WEST SUSSEX COUNTY COUNCIL CONSULTATION

TO:	Arun District Council FAO: Anita Gardner
FROM:	WSCC - Highways Authority
DATE:	15 December 2020
LOCATION:	Woodies Newsagents, The Square, Angmering, BN16 4AE
SUBJECT:	A/189/20/PL Provision of permanent outside seating & awning. This application may affect the setting of a listed building, affects the character & appearance of the Angmering Conservation Area & is in CIL Zone 2 (Zero Rated) as other development.
DATE OF SITE VISIT:	N/A
RECOMMENDATION:	More Information
S106 CONTRIBUTION TOTAL:	N/A

Site Plan 1:100

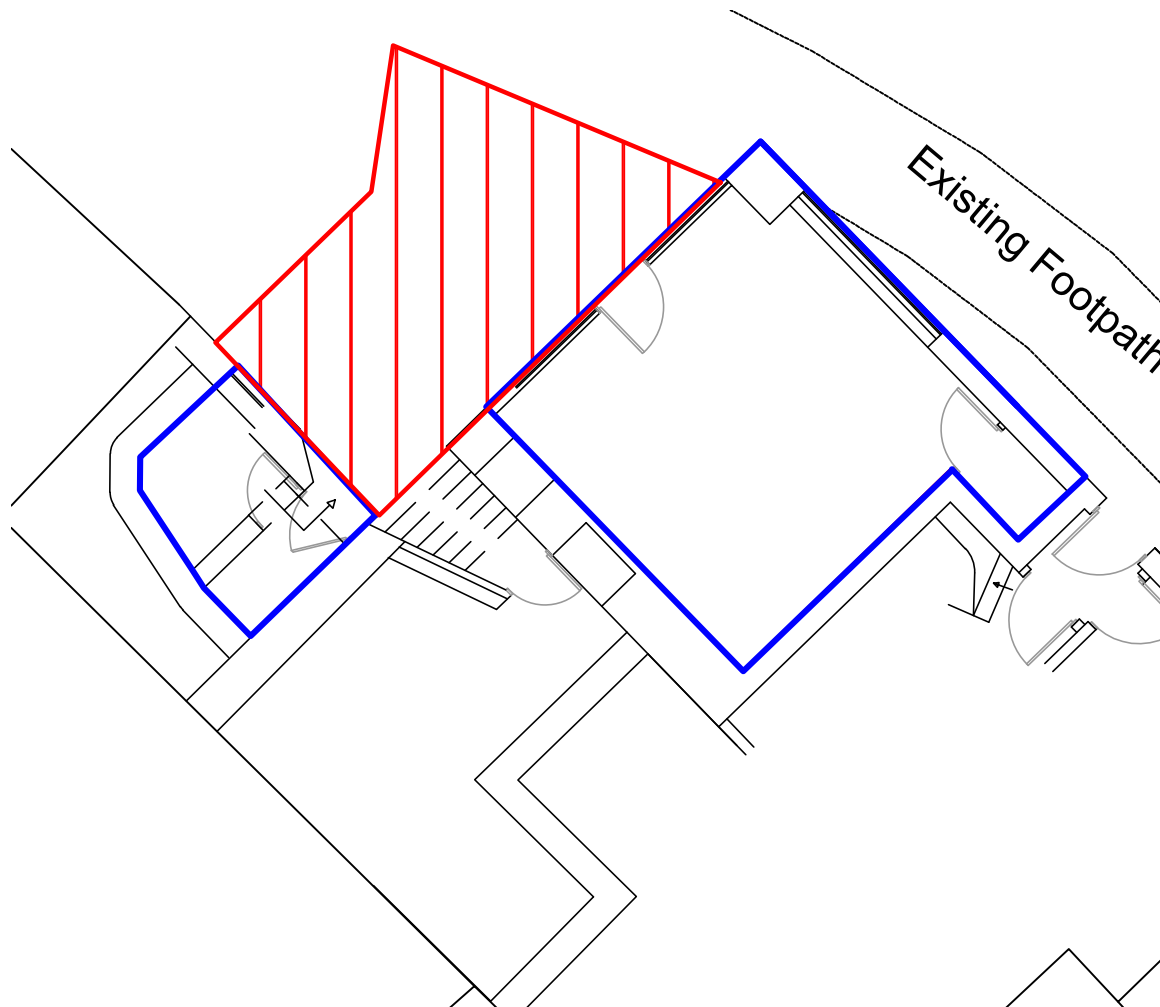
The Design & Access Statement states that the positioning of the outdoor seating area will allow for a 2m wide footpath adjacent to the seating area. However, from inspection of the Site Plan, the footpath adjacent to the seating area appears to vary between 1.6m and 1.8m in width. This does not meet the minimum unobstructed width of footways for pedestrians of 2m as outlined in Manual for Streets 6.3.22. The LHA requests the plans be modified to ensure a footway width of 2m is achievable along the boundary of the proposed seating area.
